Comments from Gareth Moor/Colin Moor Deadline 4

Following on from the stage 3 hearings I feel I must once again raise my objections to part of the scheme. The area I object to be the works proposed to West View and the proposed tracks servicing Northgate Farm Warreners House and Stafford House and the proposal to use these roads for agricultural traffic .

Figure 1 – DCO Application proposed PMA Route

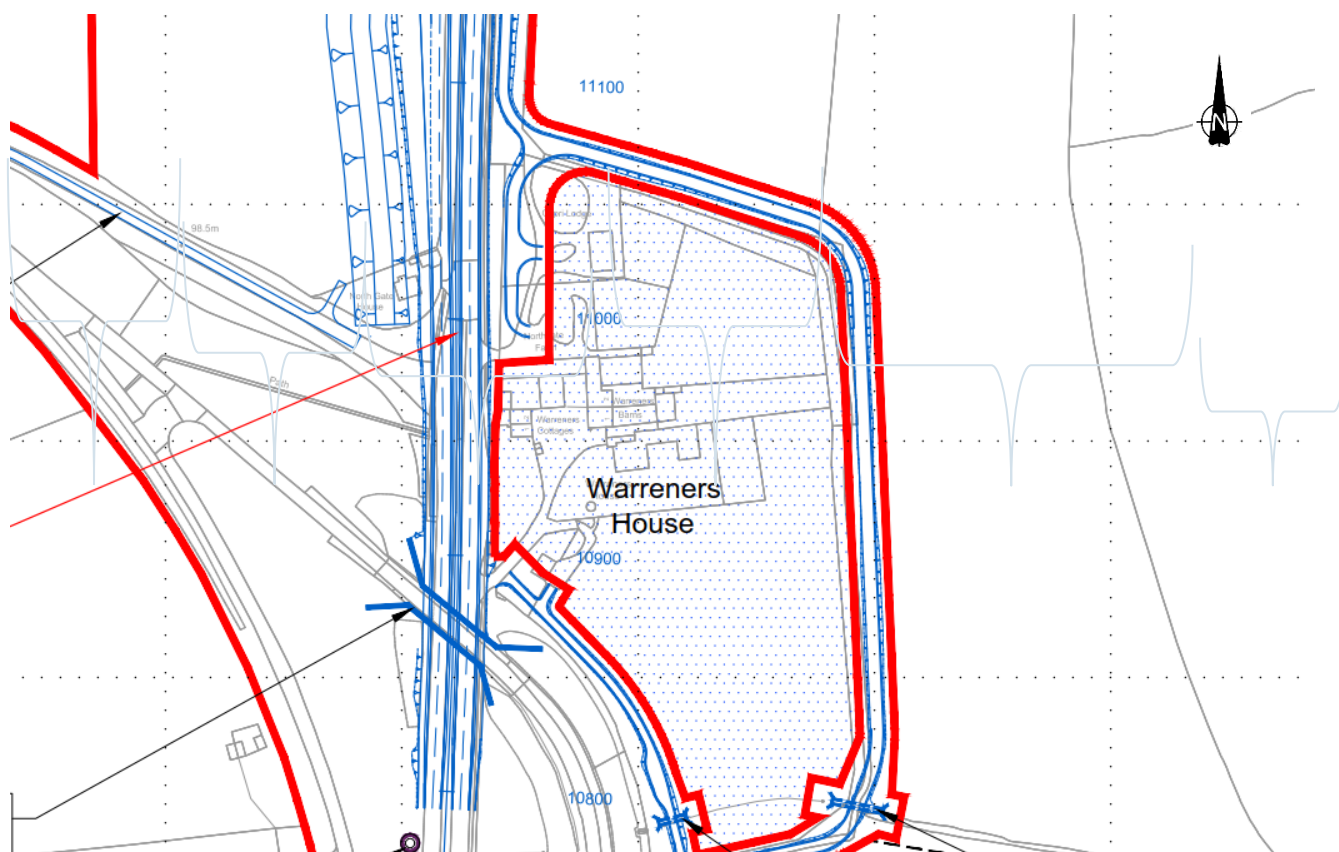
The current proposals are not the safest options available the safest route and more practical route is to build is a northern route

My reasons for this are I doubt that at design stage a complete and sufficient risk assessment has been undertaken as required by the CDM Regulations in deed the applicants response is to allude to a small number of additional vehicles using the road in addition to this a small number of agricultural vehicles. There is no acknowledgment to the number of people or other traffic that these vehicles impact on. In short who could be harmed? Had this been undertaken it would clearly indicate that the level of Risk and the potential for that risk been released is significantly much higher diverting the road South as opposed to North

4 This design would eliminate all agricultural traffic from a residential street and eliminate the risk to the residents of two new housing estates, hospital complex users, and West View occupants, visitors, and delivery personnel. In Short the risks are completely designed out, a fundamental requirement of the regulations that has not been adhered to in the proposed design.

5 This route would eliminate the modifications and removal of the Gas pumping Station at the North end of West View

7 This route will eliminate the concerns I have regarding flooding due to the proposed works.

Figure 2 - Alternative Route A

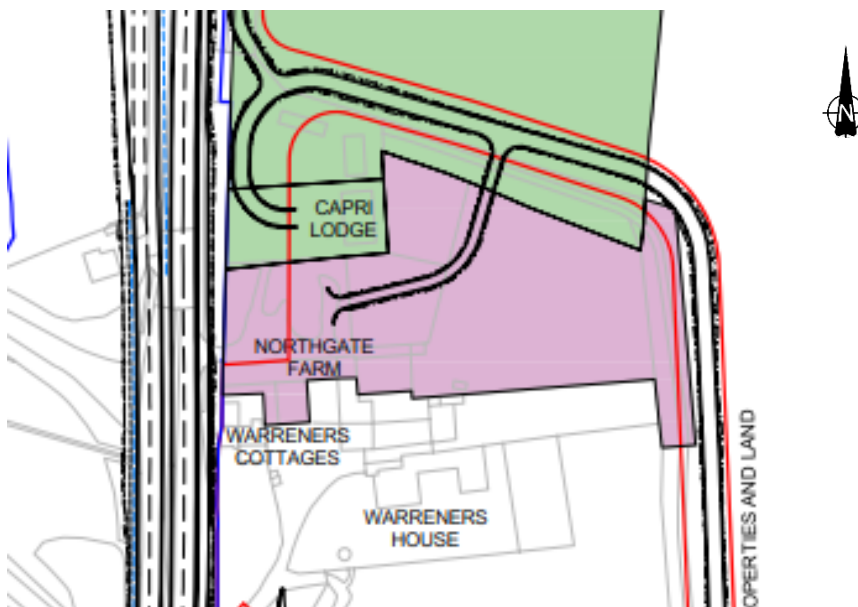
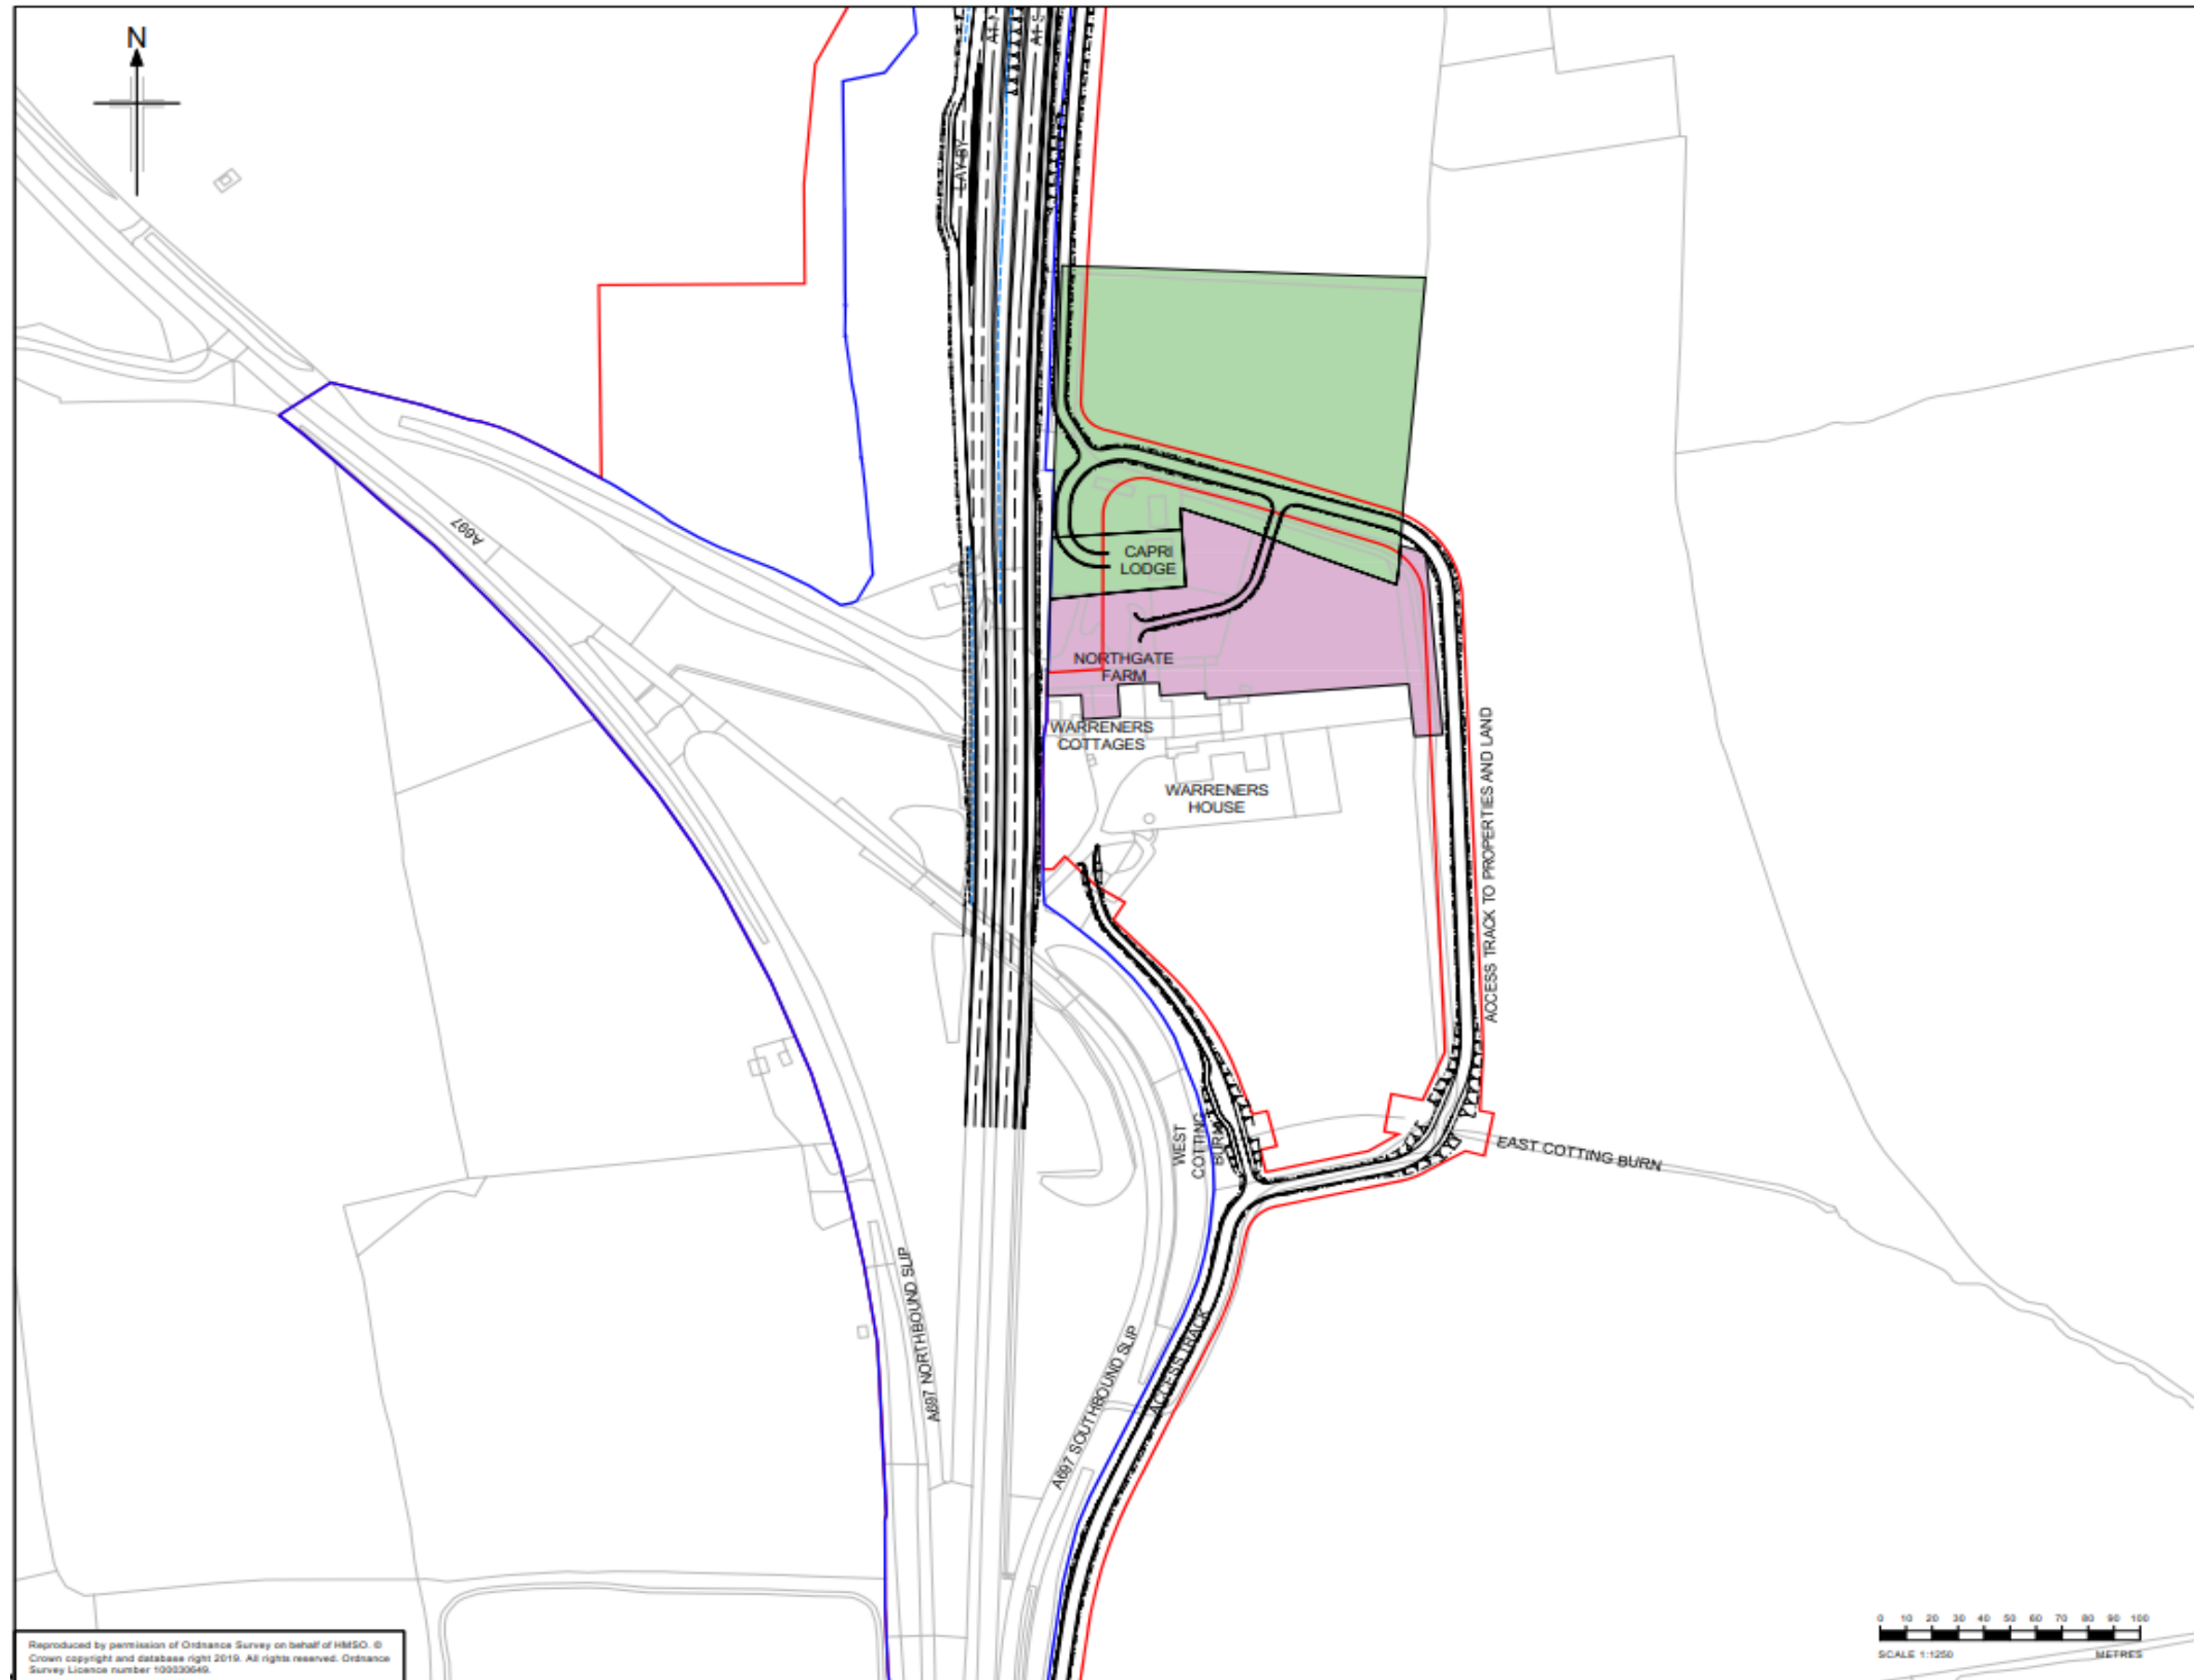
1 It is more practicable to work in a field with no other vehicular traffic or people for the majority of the time where ingress and egress can be easily controlled and the track built from North to South in a progressive manner and very safe manner

2 If designed correctly there is the potential to remove two proposed culverts from the scheme. Whilst the Environment Agency have commented on the scheme it is their preference to remove or not to culvert wherever possible

3 The specification for the proposed track is not to adoptable standard therefore will be considerably more cost effective than the works to West View.

I would also contend that the applicants assertion that the proposed road/track is shorter than a northern route is not correct I have previously provide dimension regarding this, these indicates that designed correctly it can be shorter.
